**EL PASO COUNTY PLANNING & COMMUNITY DEVELOPMENT  
SIGN APPLICATION**

Name: Fred Loya Insurance  
Address: 7376 McLaughlin Rd  
Falcon, CO 80831

Proposed 23" x 192" Front Lit Channel Letters. Installed on raceway and secured using 3/8"X5" non corrosive fasteners.

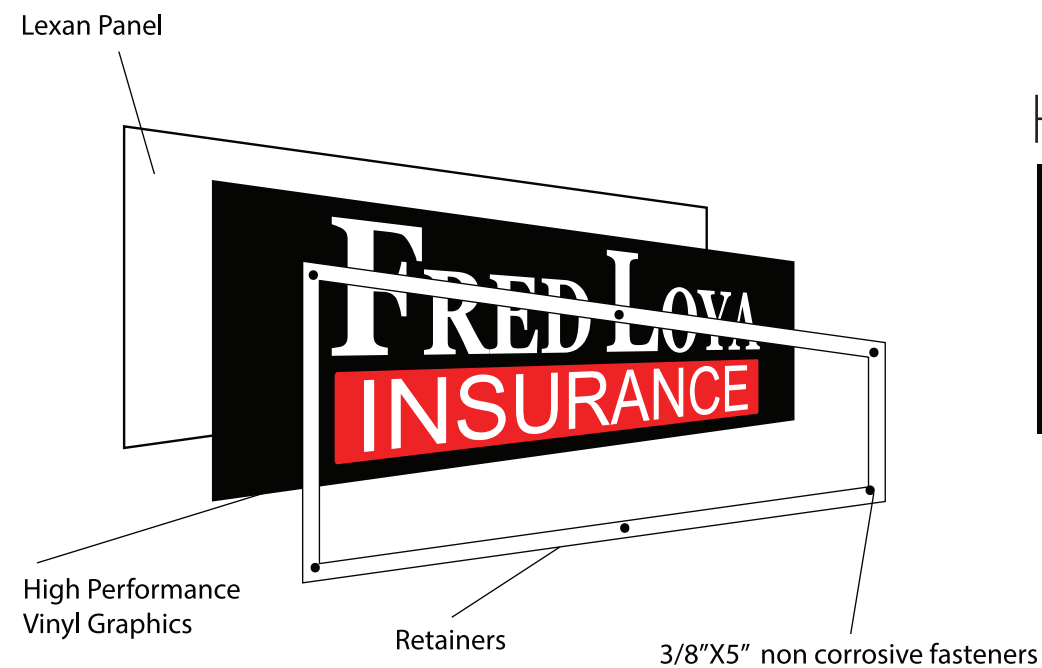
Appears that a total of 52 square feet of wall signage is proposed, exceeding maximum allowance. Revise and resubmit, or clarify.
